WEST SUSSEX COUNTY COUNCIL CONSULTATION

TO:	Arun District Council FAO: Simon Davis
FROM:	WSSC – Highways Authority
DATE:	10 November 2025
LOCATION:	Land West of Pagham Road Pagham PO21 3PY
SUBJECT:	P/135/25/DOC Approval of details reserved by condition imposed under P/178/21/OUT (APP/C3810/W/22/3302023) relating to conditions 9-recommendations of supporting survey reports, 10-resurvey for water voles or badgers and 16-Construction and Environmental Management Plan (CEMP). Amendment to application dated 6th November 2025 relating to: Substitute CEMP
RECOMMENDATION:	No Objection

7. Off site traffic Management

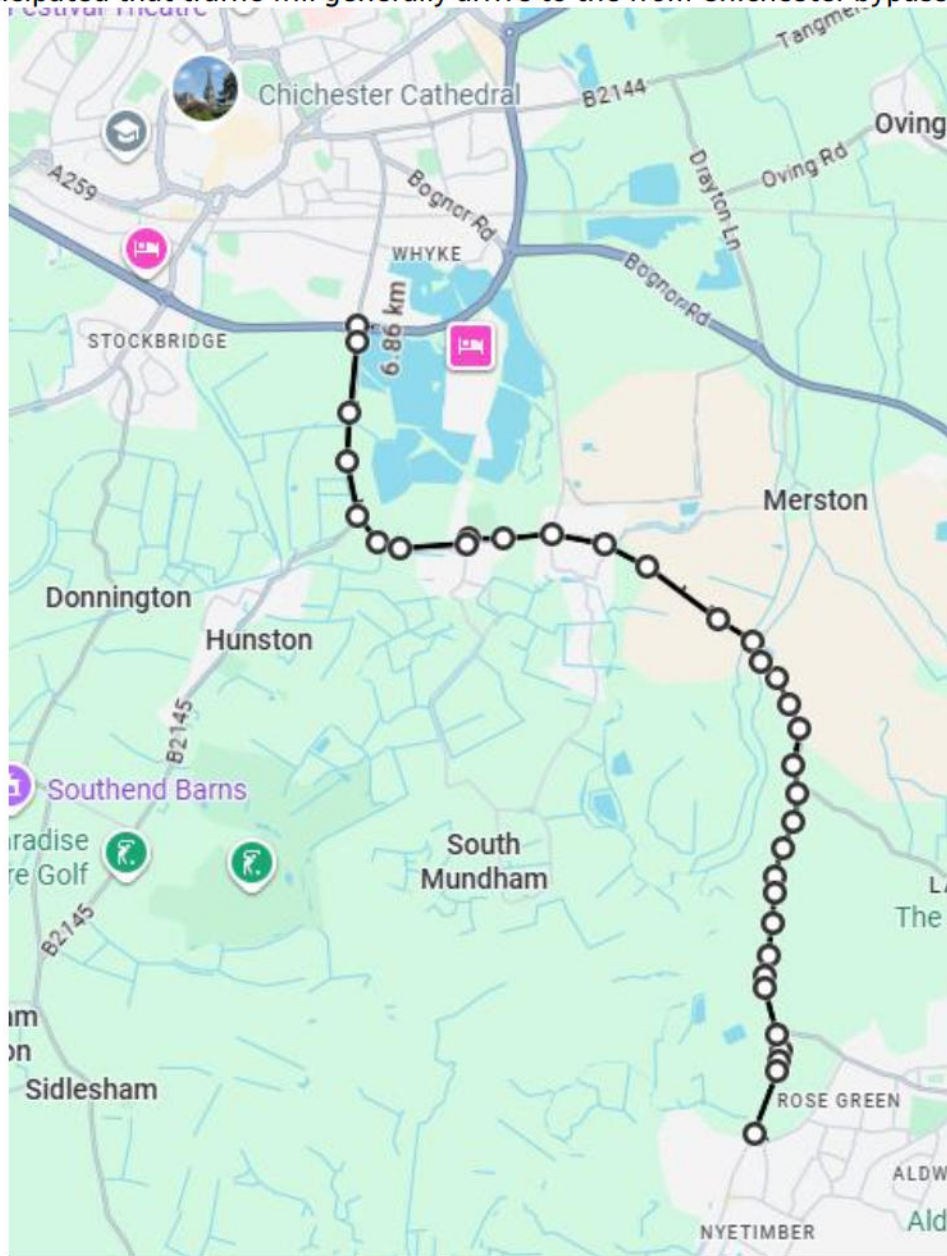
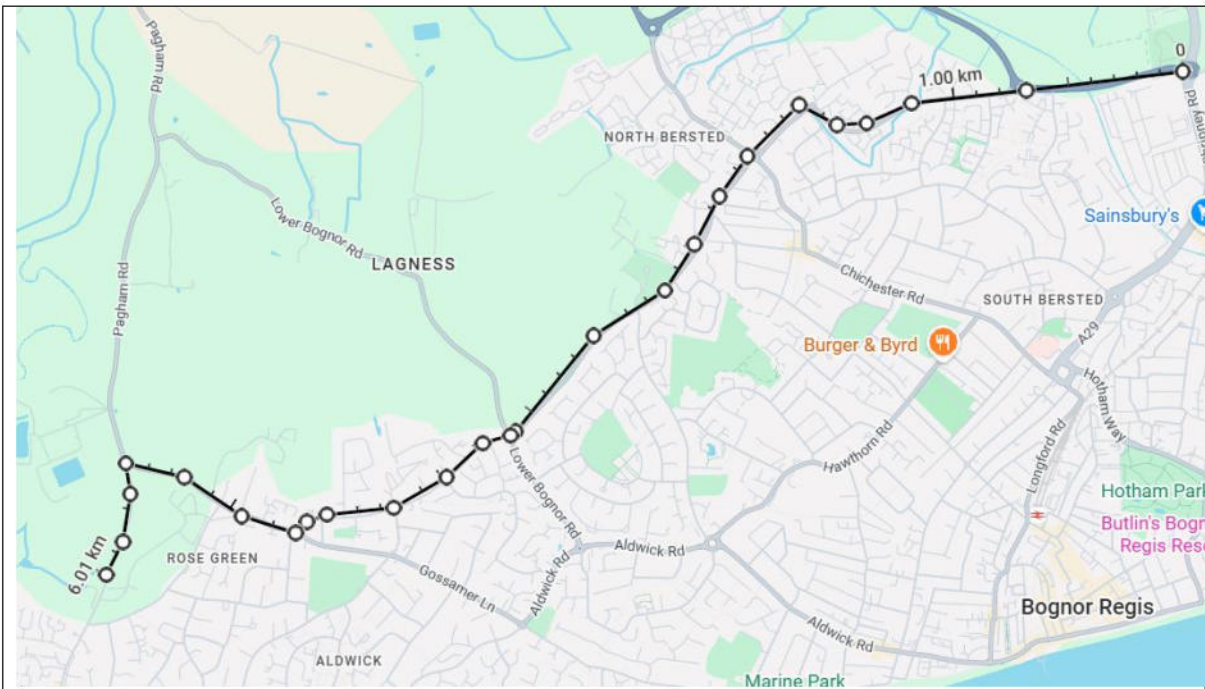
WSSC Highways have previously commented on the Construction Management Plan submitted for condition 16. Two matters were raised in respects of the initially submitted construction management plan; routing for vehicles arriving/departing to the east and parking for operatives.

With regards to the points previously raised, a routing arrangement is shown for vehicles arriving and departing to the east. This makes use of the most suitable roads available. Concerning parking, the revised CMP includes no great level of additional information. It does though include a commitment that all parking associated with the development will take place within the site itself. The developer will therefore need to manage car parking demands within the available site as the development progresses.

Based on the revised CMP, WSSC Highways would advise that condition 16 can be discharged.
